Our Ref: AW/5/20/T
Your Ref:

Town & Country Planning Act 1990 (as amended)
Town & Country Planning (Tree Preservation) (England) Regulations 2012
Application for Works to Tree(s) on trees subject to a Tree Preservation Order (TPO)

Development Fell 1 No. Oak tree (T1). Reduce 3 No. Oak trees (T2, T3, T4).
Location 1 Seabrook Close Aldwick

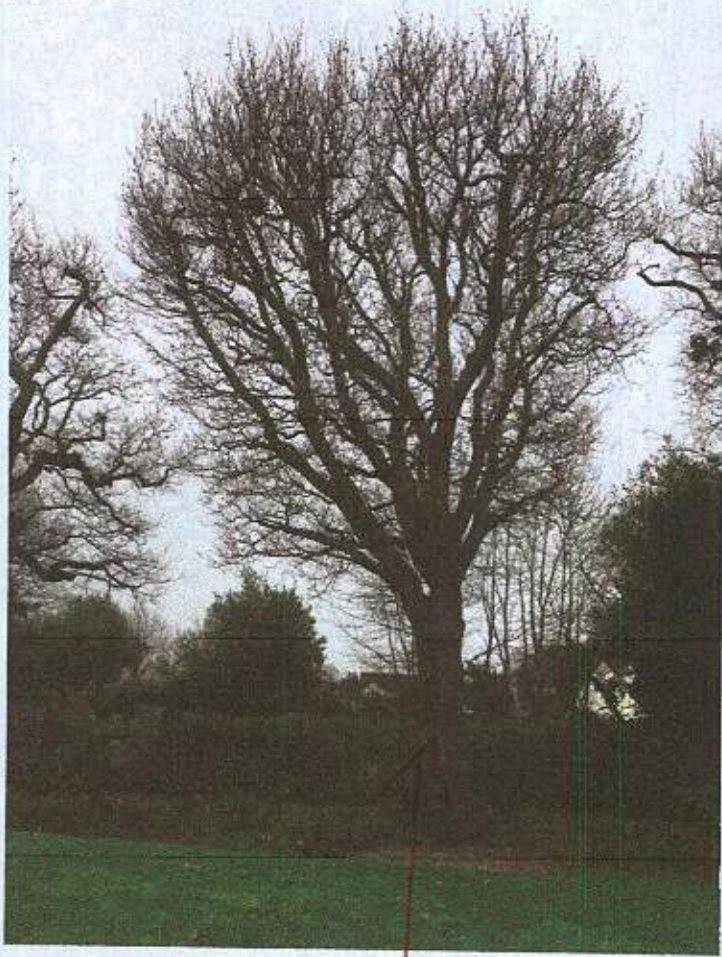
Please confirm if proposed works to 3 No. Oak trees is a Crown Reduction.

Please provide the proposed measurements for each tree after reduction/pruning.
